Recommendation Report for Planning Permission for Works or Extension to a Dwelling

REF NO: LU/257/20/HH

LOCATION: 2 Meadow Way
Littlehampton
BN17 6BW

PROPOSAL: Two storey brick side extension under tiled roof

Ground Floor Plan

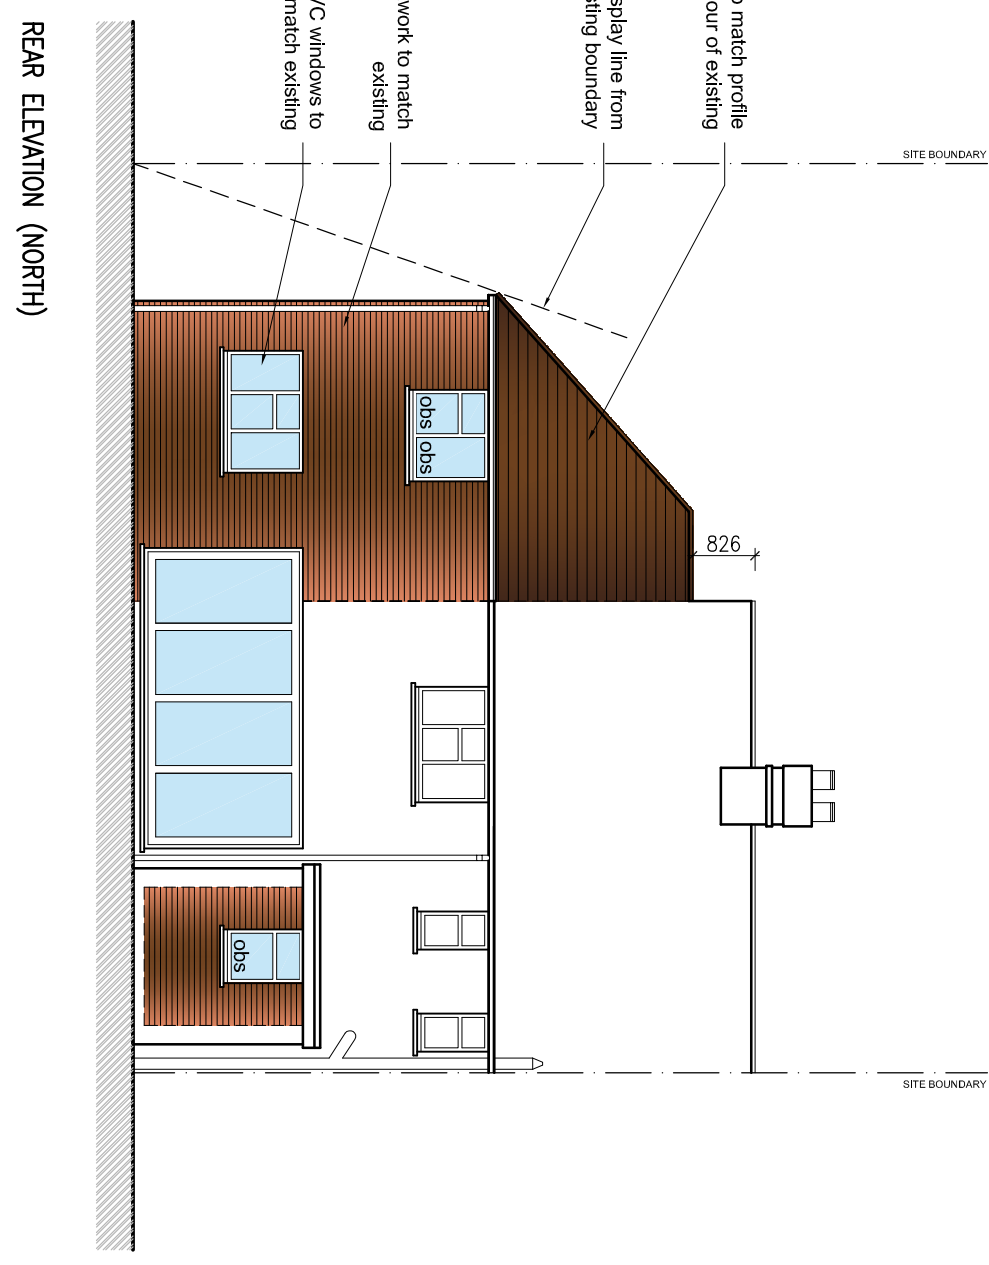
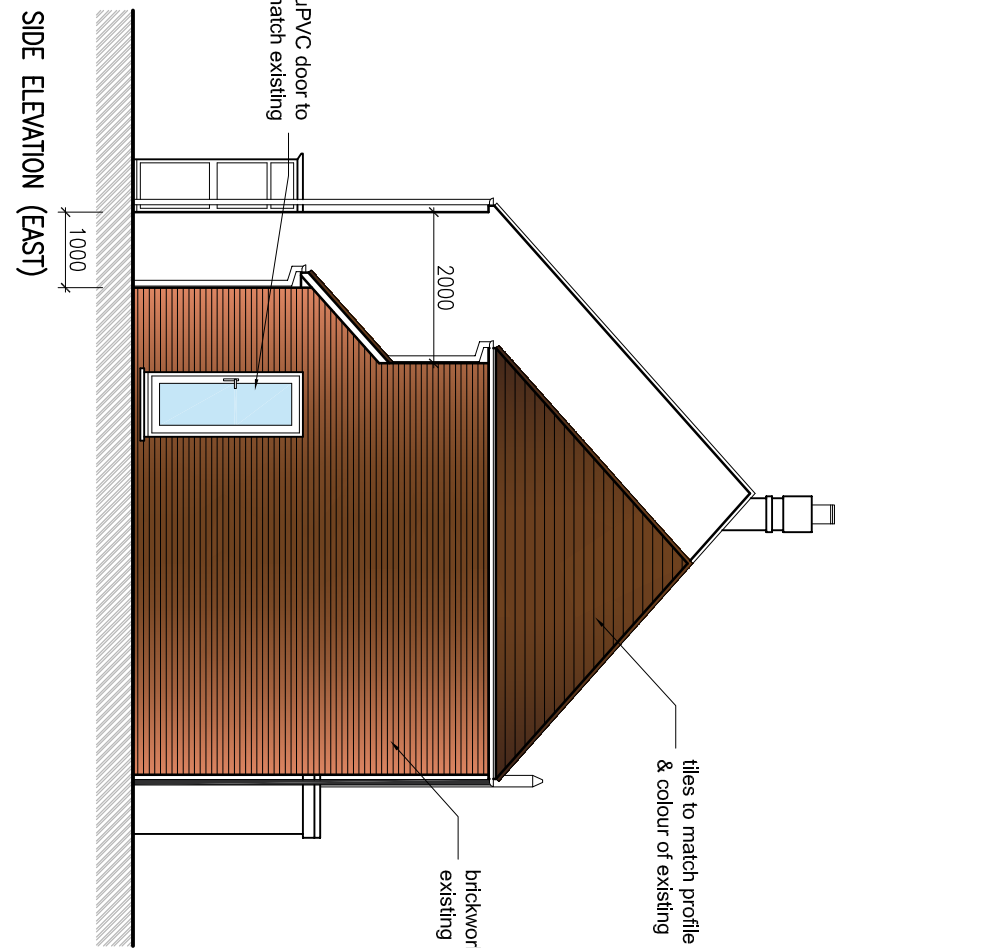
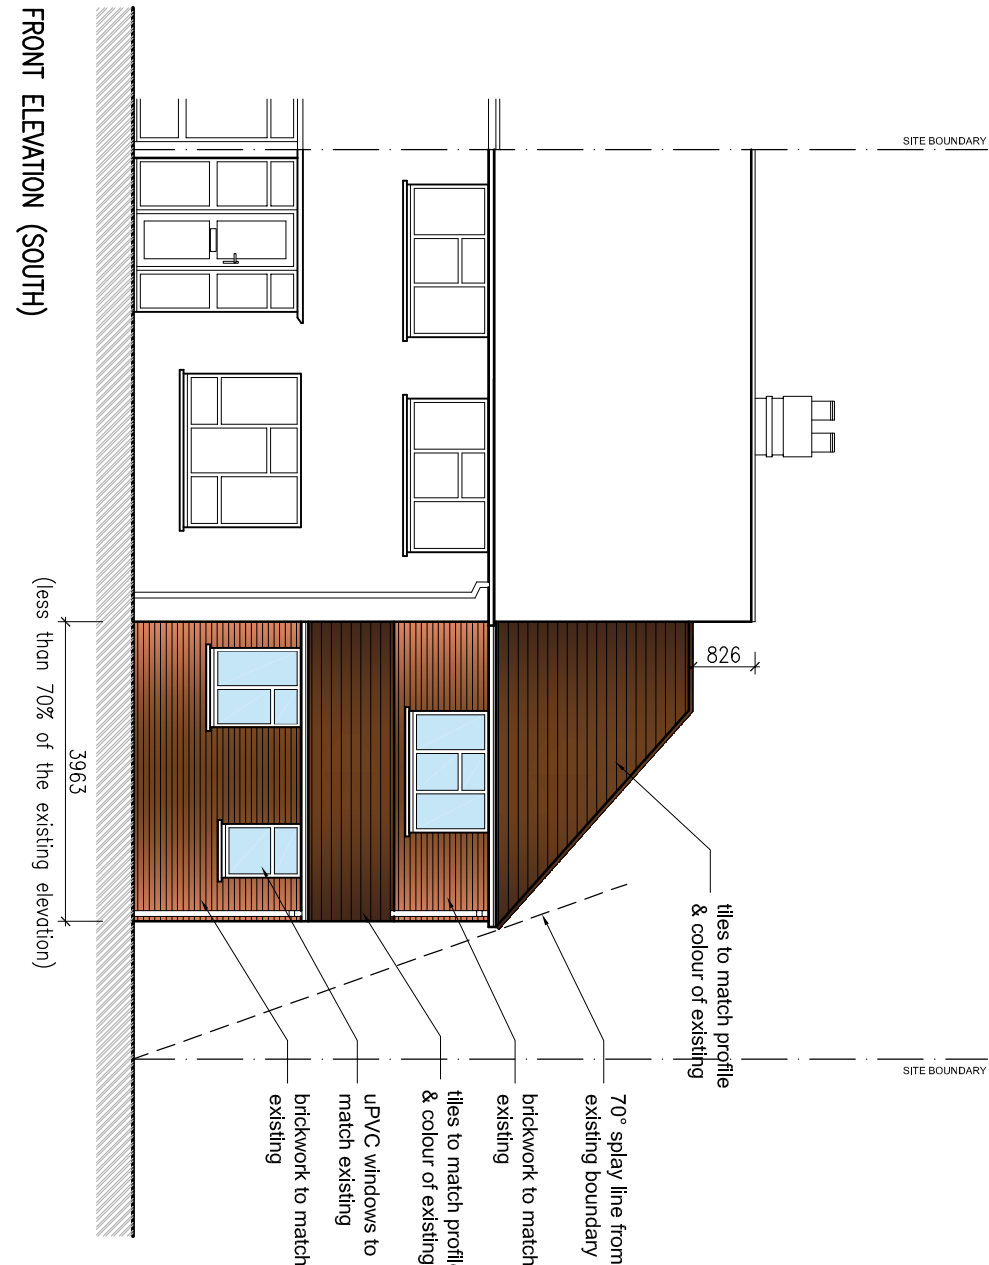
Due to its siting, the development would be highly visible in the street scene of Meadow Way and Esher Drive. As such, there are views of the extension from the immediate and wider locality given the existing prominence of the property within the street scene. The existing Eastern wall of the host dwelling is approximately 6m from the boundary, in conformity with the character and appearance of the area, being characterised appearing reasonably spacious and open, due to the built form being set back from the street scene in a constant and uniform manner. Whilst the set back nature of the proposal from the street scene, and the ridge height are noted as allowing the extension to appear subservient to the host dwelling, it is considered to appear as an alien feature within the wider locality, and have a harmful impact upon the uniform character of the Northern side of Meadow Way.

The development is considered to appear as an alien feature within the locality, and as such, will result in a significantly harmful impact upon the character of the locality, and its established spatial pattern. The proposed development is considered to be in accordance with D DM4(b) of the Arun Local Plan however, it conflicts with D DM1 and D DM4(e) of the Arun Local Plan.

- 1 The proposed development is considered to result in a harmful impact upon the character and spatial pattern of the locality by way of its siting, form and design contrary to D DM1 and D DM4(e) of the Arun Local Plan.
